## **AQUIND Interconnector**

### **Application by AQUIND Limited for an Order Granting Development Consent**

#### **Local Impact Report**

#### **Havant Borough Council**

© WSP UK Ltd

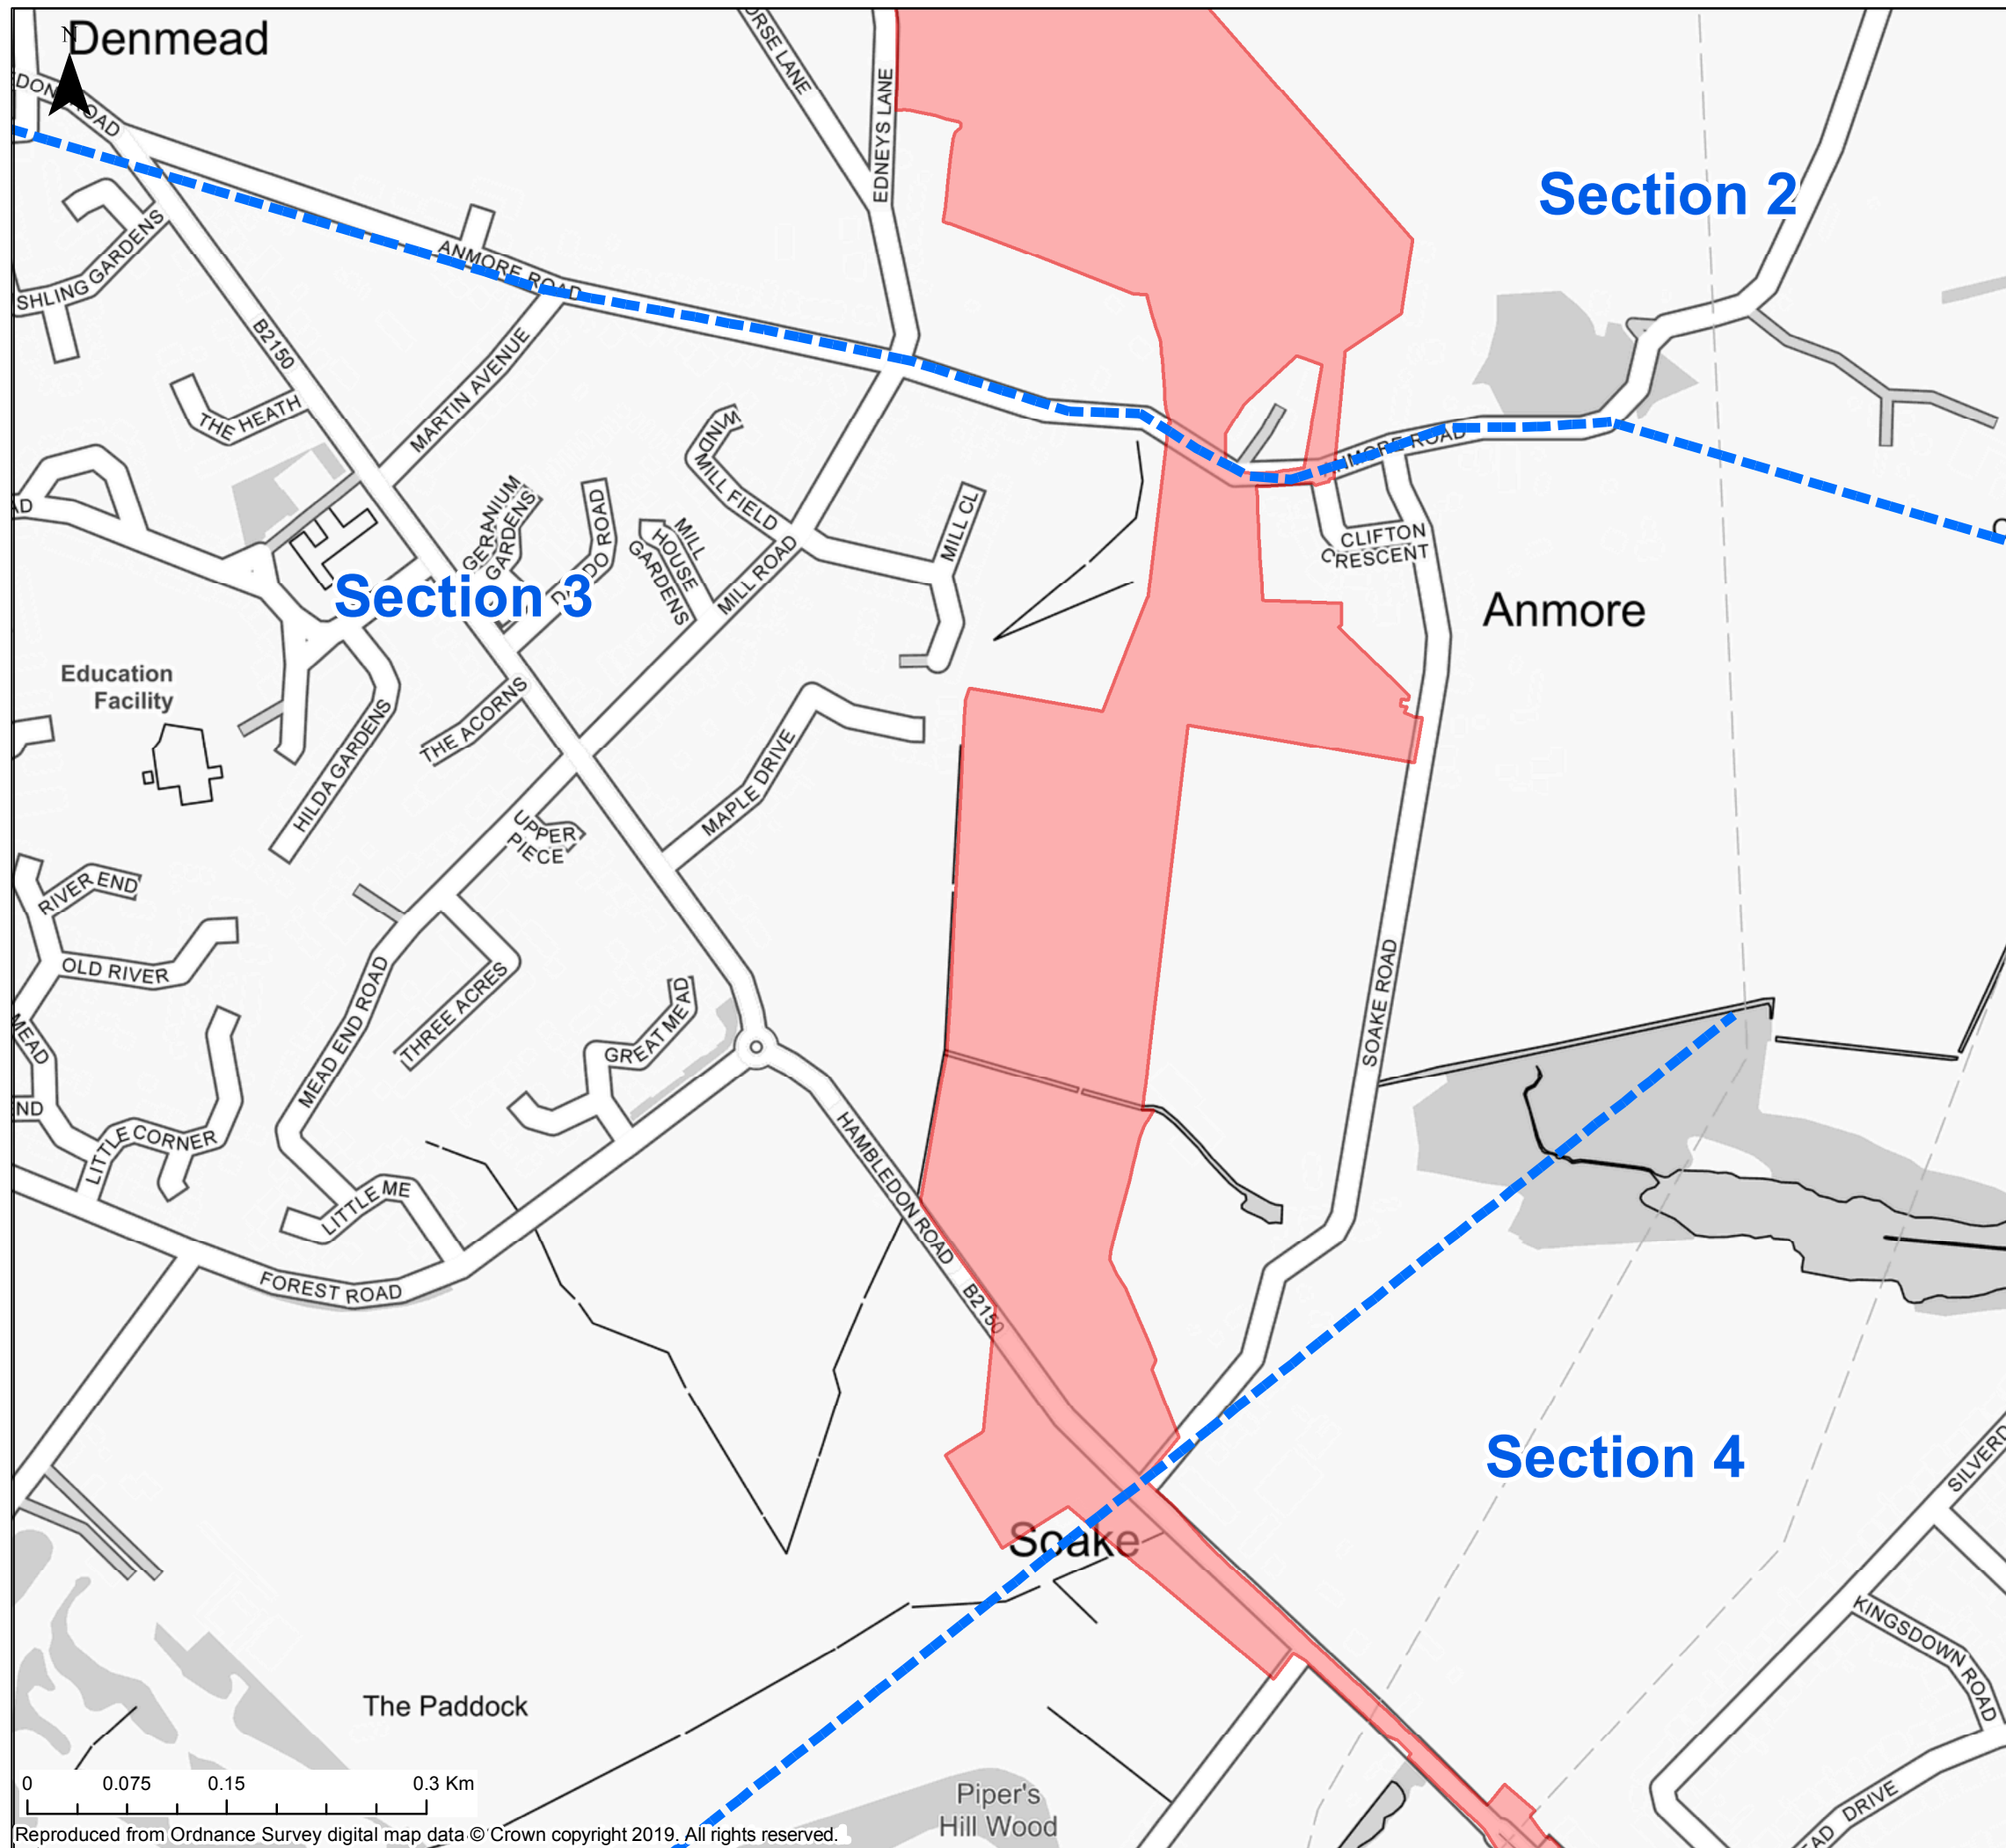
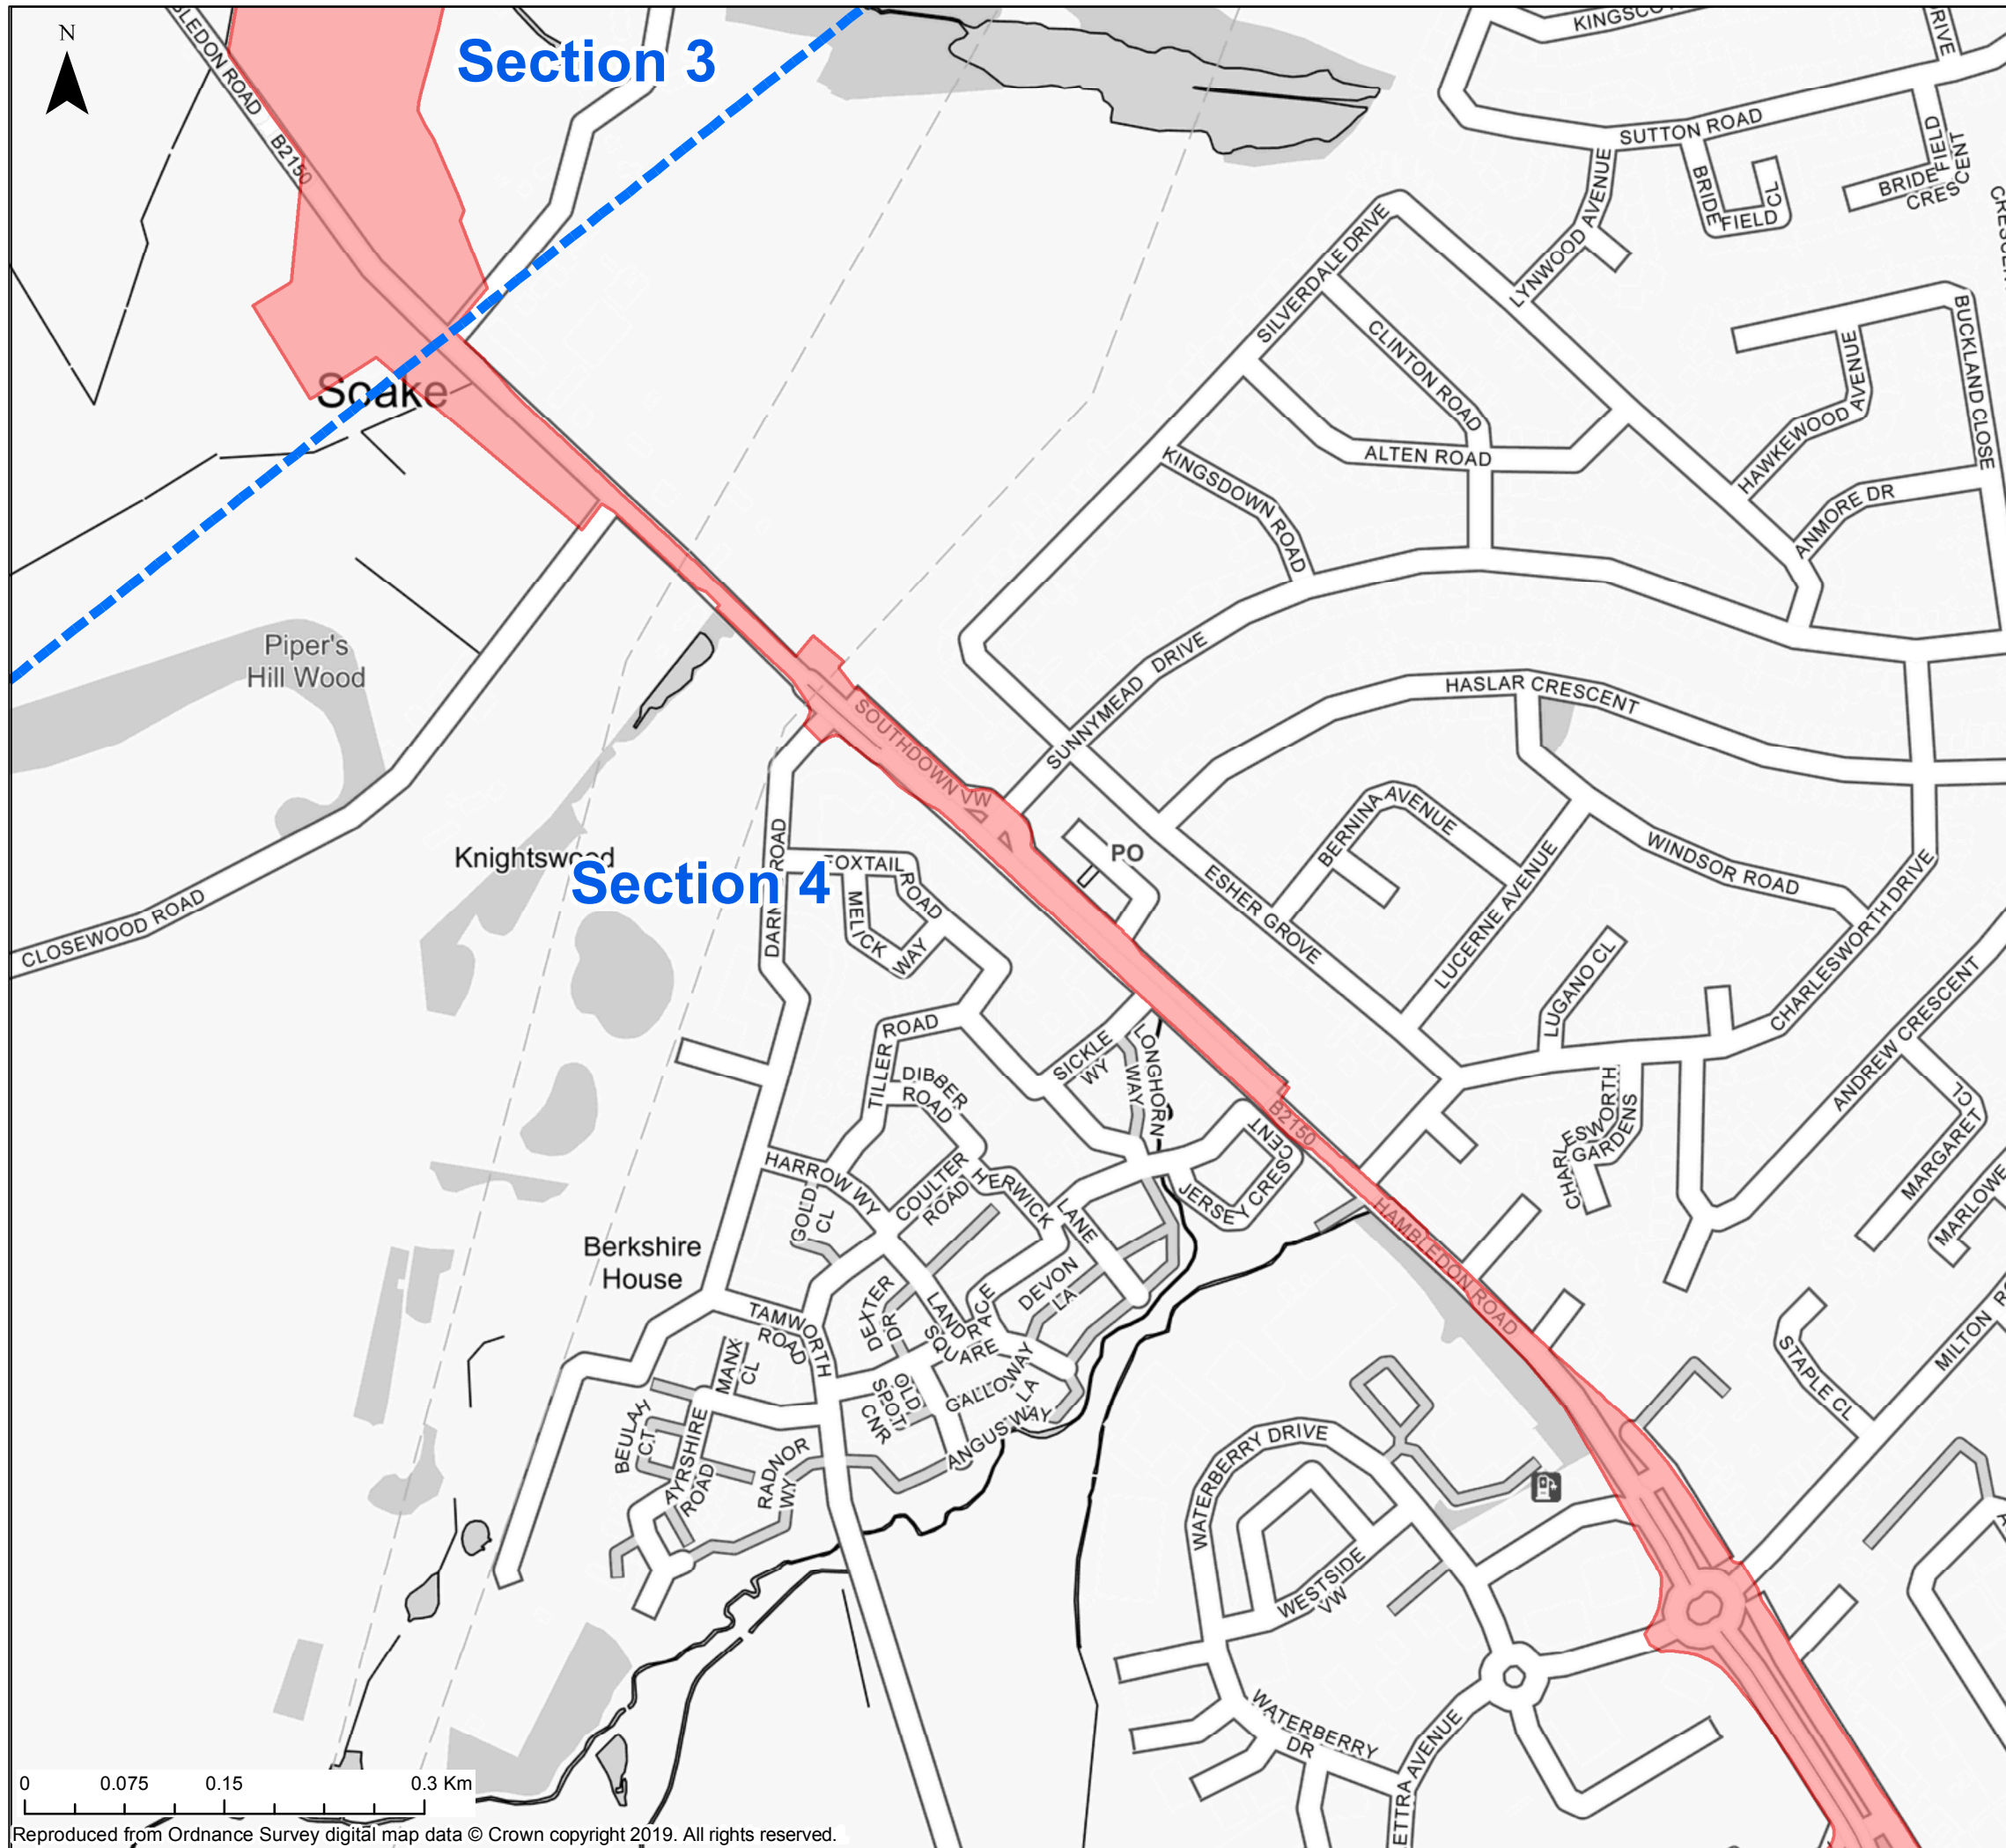
8. The proposed route of the cable along the highway network within the administrative control of Hampshire County Council is shown on sections 1-4 of the onshore cable corridor plans. This brings the cables from the proposed converter station site at Lovedean down to the Portsmouth City Council boundary at the A3 London Road (south of The Dale). The route primarily runs along the A3 corridor and B2150, which are highly trafficked, important priority bus routes, and play a key role within the local network. The cable route corridor in this area caters for the bus 'Star' routes 7 and 8 between Portsmouth and Waterlooville which is a key access facility to Queen Alexandra Hospital and Portsmouth's employment areas.

16. A plan showing the highway boundary overlaying the order limit should be provided to enable a clear understanding of the highway land affected. This can be obtained from HCC's Asset Information Team [assetinformation@hants.gov.uk](mailto:assetinformation@hants.gov.uk)
